PR-2022-007327

SD-2023-00220 – EXTENSION OF PRELIMINARY PLAT

SD-2023-00222 – EXTENSION OF (8) VACATIONS OF PRIVATE EASEMENT

REQUEST: EXTENSION OF OUR APPROVAL FOR PRELIMINARY PLAT (PR-2022-007327/SD-2022-00188) TO ADJUST THE INTERIOR LINES OF FOUR EXISTING TRACTS TO CREATE FOUR NEW LOTS AND DEDICATE A PORTION OF RIGHT-OF-WAY TO EXTEND THE PUBLIC PORTION OF CUTLER AVE., EXTENSION OF VACATION OF PORTIONS OF 8 EASEMENTS (PR-2022-007327/SD-2022-00189-197)

**Site Sketch for  
Tracts A-1-A-1, A-1-B-1-A,  
A-1-B-2-A and A-1-B-3-A-1  
Acme Acres  
Being Comprised of  
Tracts A-1-A, A-1-B-1, A-1-B-2  
and A-1-B-3-A, Acme Acres  
City of Albuquerque  
Bernalillo County, New Mexico  
November 2022**

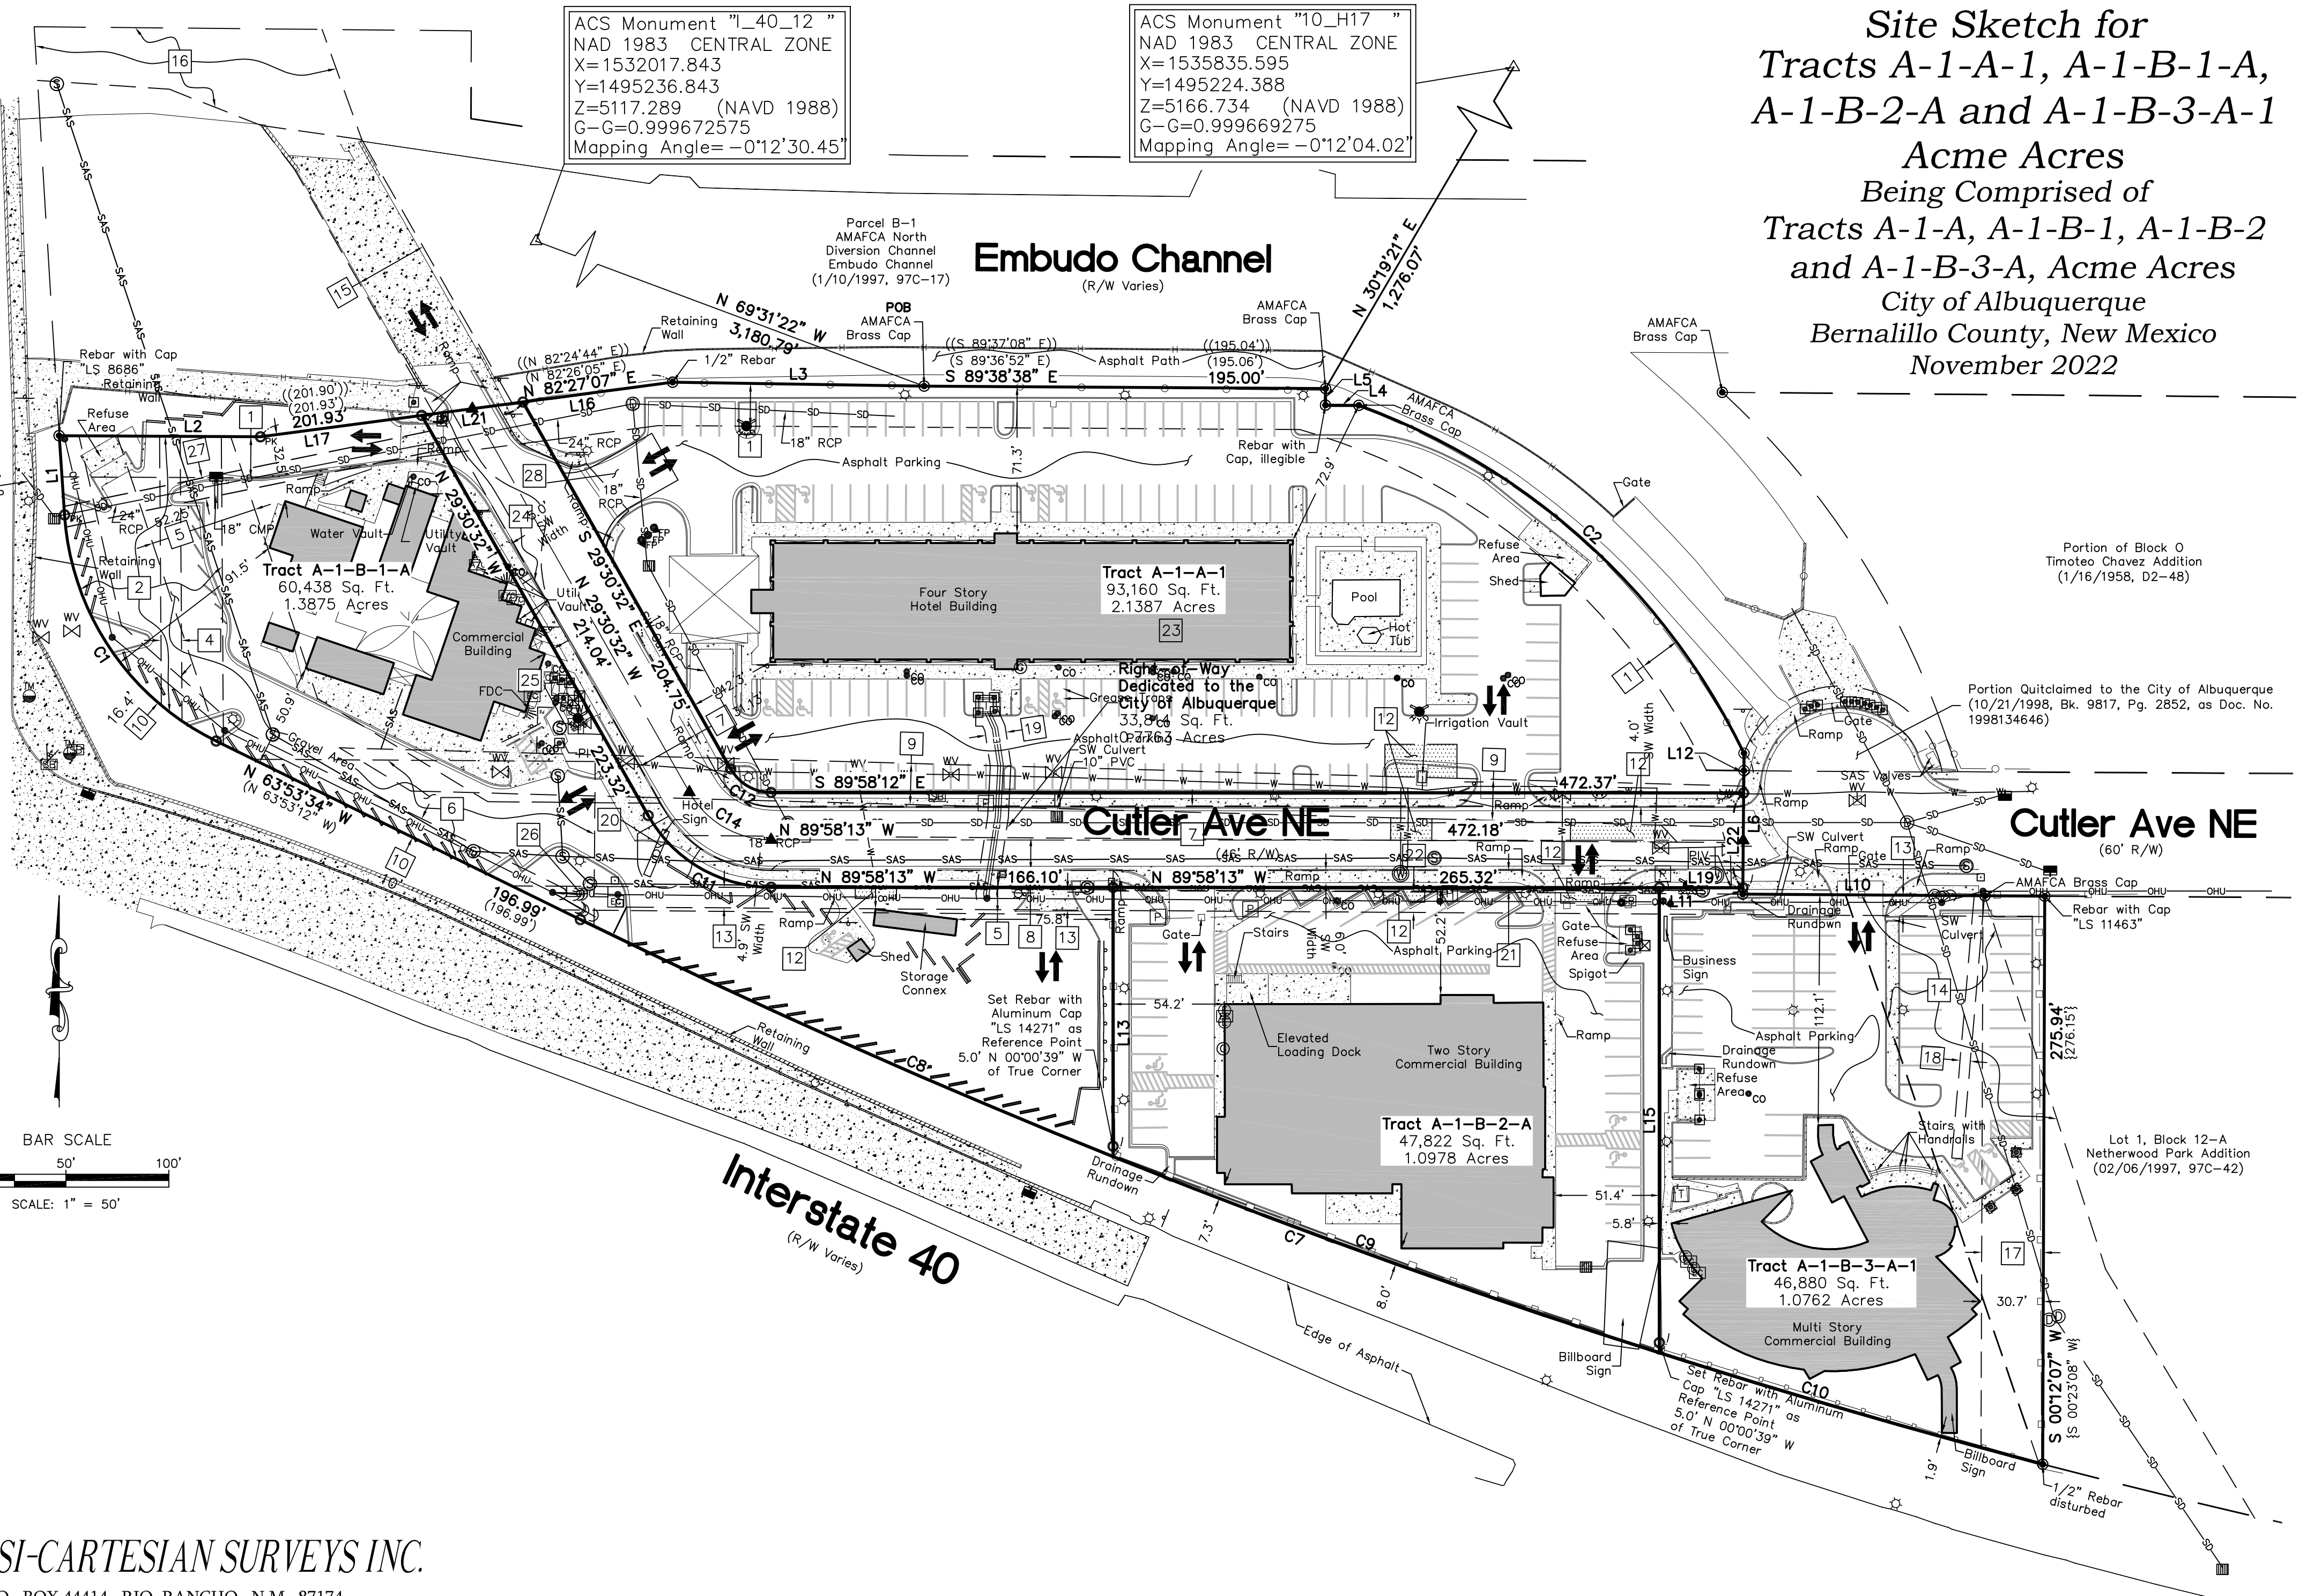
1. No objection to the extension
 - a. Note that previous conditions still need to be met as discussed.
 - i. Reference recorded Notice of Encroachment for the existing Hampton Inn sign that was installed without any knowledge of the Water Authority (City at the time) and was done between two private parties.
 - ii. Vacate private sign easement.
